Re: M/62/17/HH Proposals at 2 Elmer Court.

Drawing No. 1645/2010D

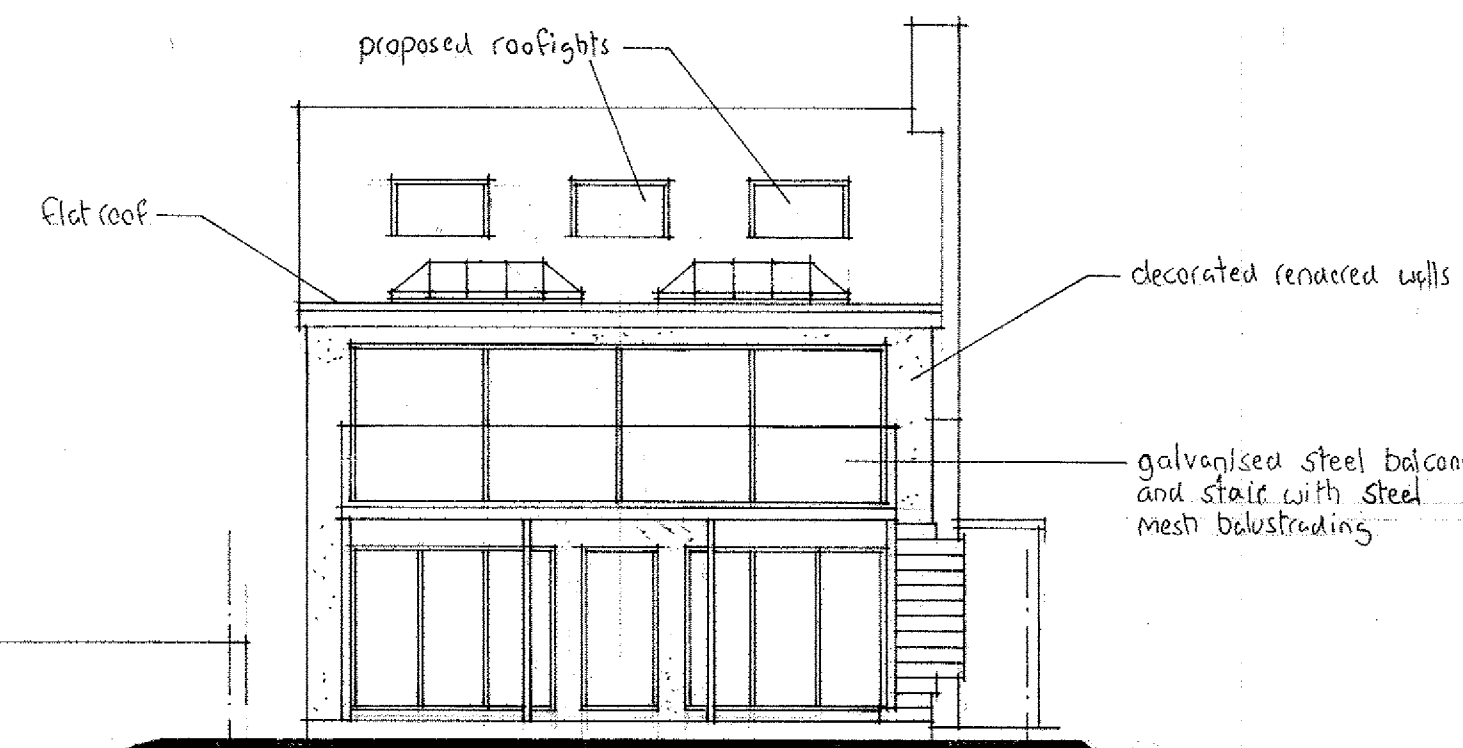
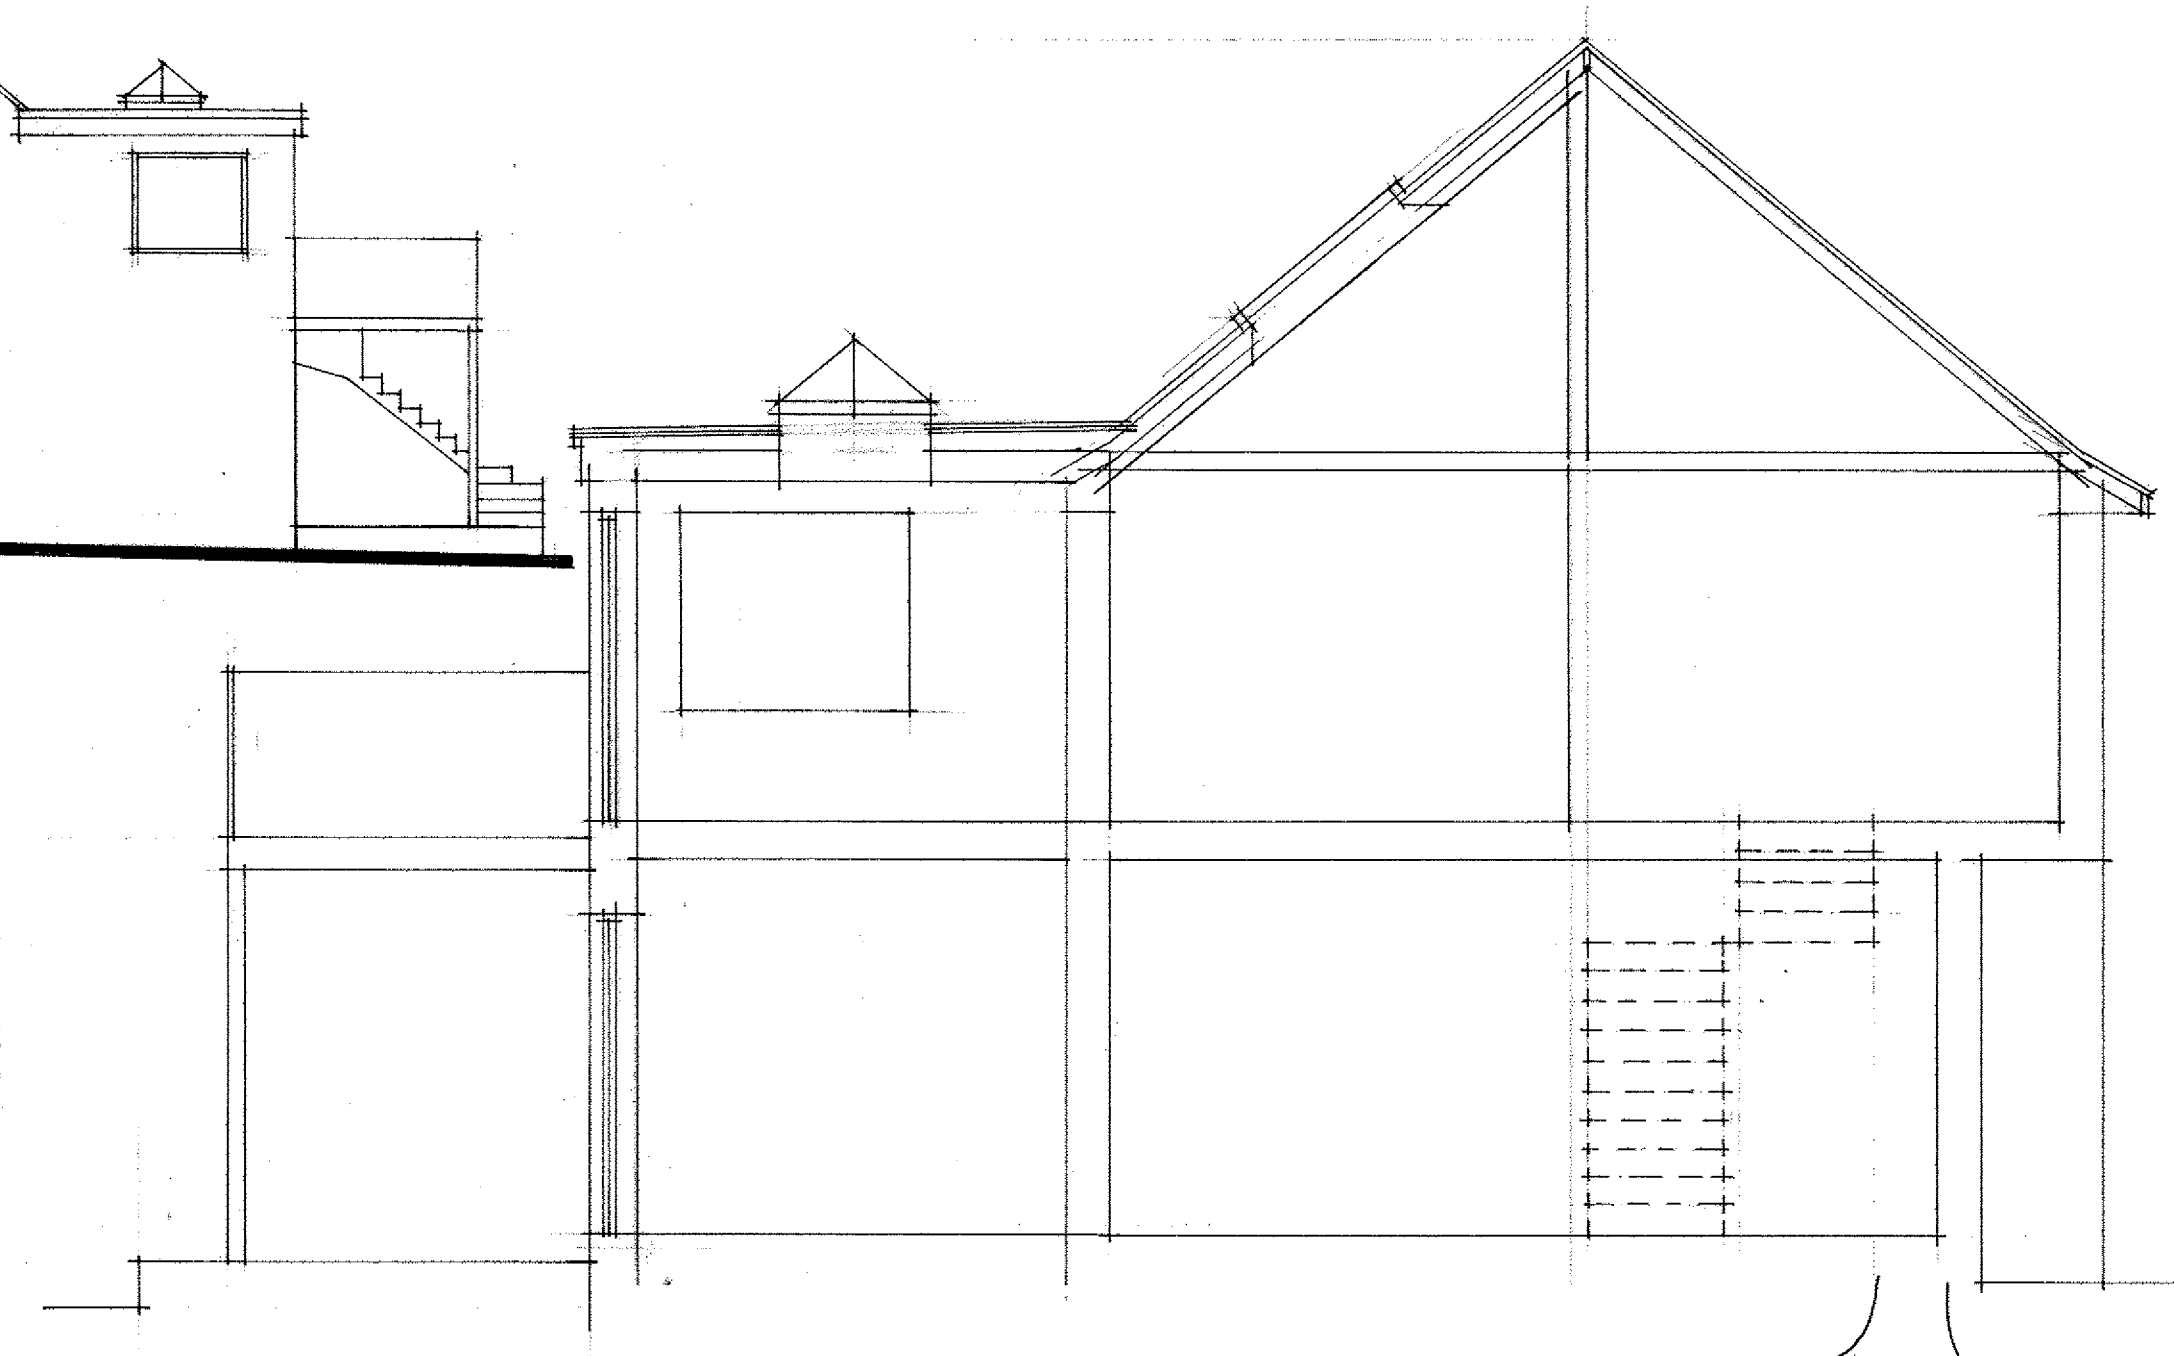
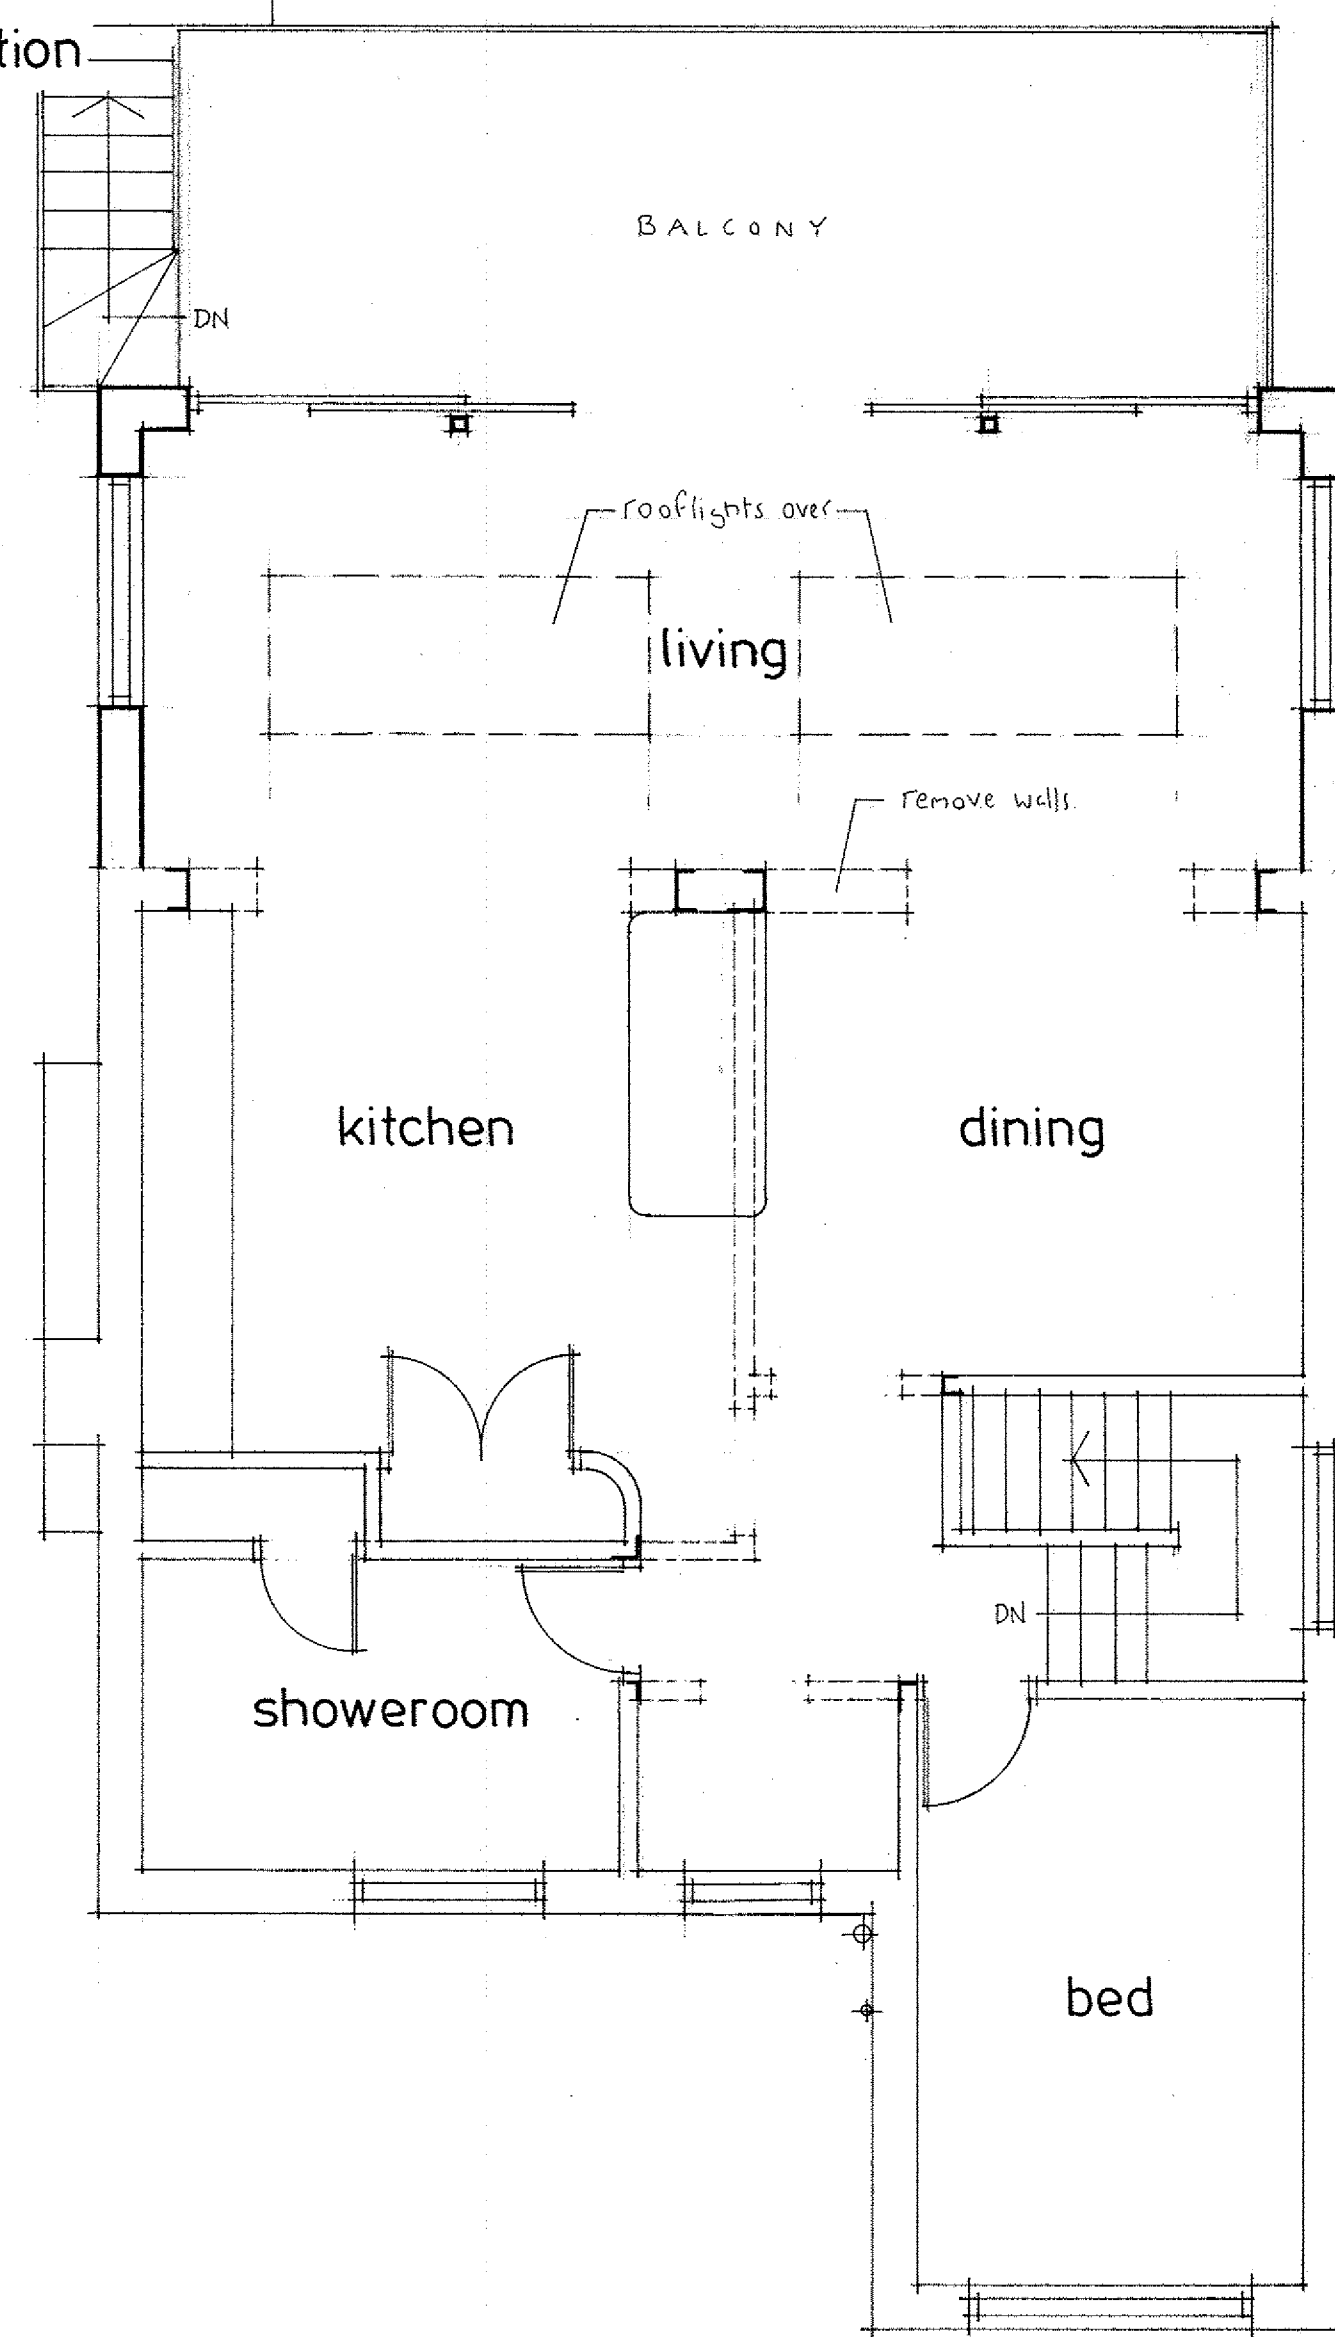
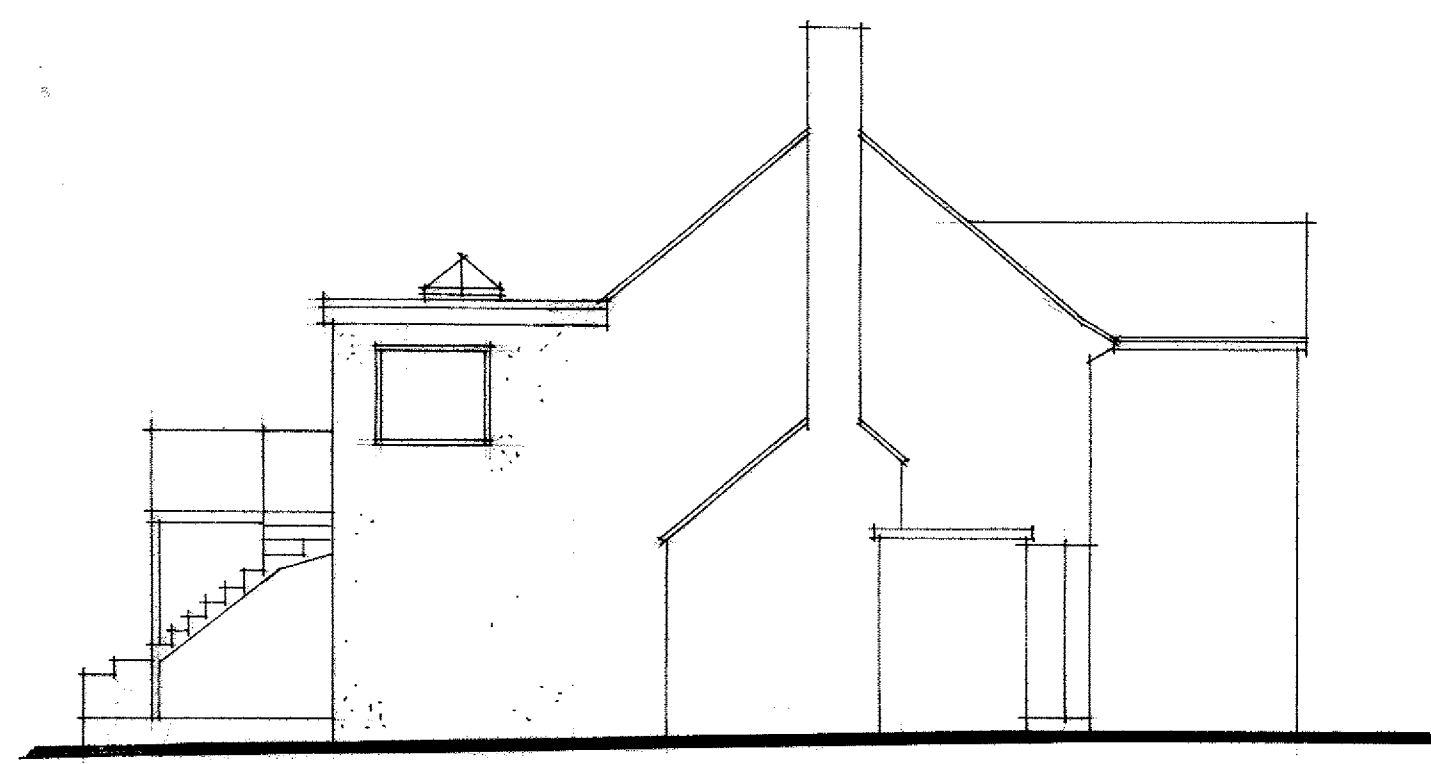
- Removal of the proposed external staircase.
- Inclusion of 1.8m high screening to the eastern and western boundaries of the proposed balcony.
- By virtue of the addition of the proposed screening it is likely that this will give rise to some additional overbearing impacts by virtue of the balconies depth – therefore, you may wish to consider reducing the depth of the balcony to mitigate against this.

1. Proposed external stair removed.
2. Balcony width reduced.
3. Glazed/stainless steel guarding shown.

We have chosen to considerably reduce the overall width of the proposed balcony from 7.3m down to 3.6m. As a result the sides of the balcony will be a good distance away from the side boundaries and neighbouring properties.

Due to this reduction in size we have chosen not to provide screening at the sides, however if you feel screening would be necessary, then we accept this (possibly as a condition).
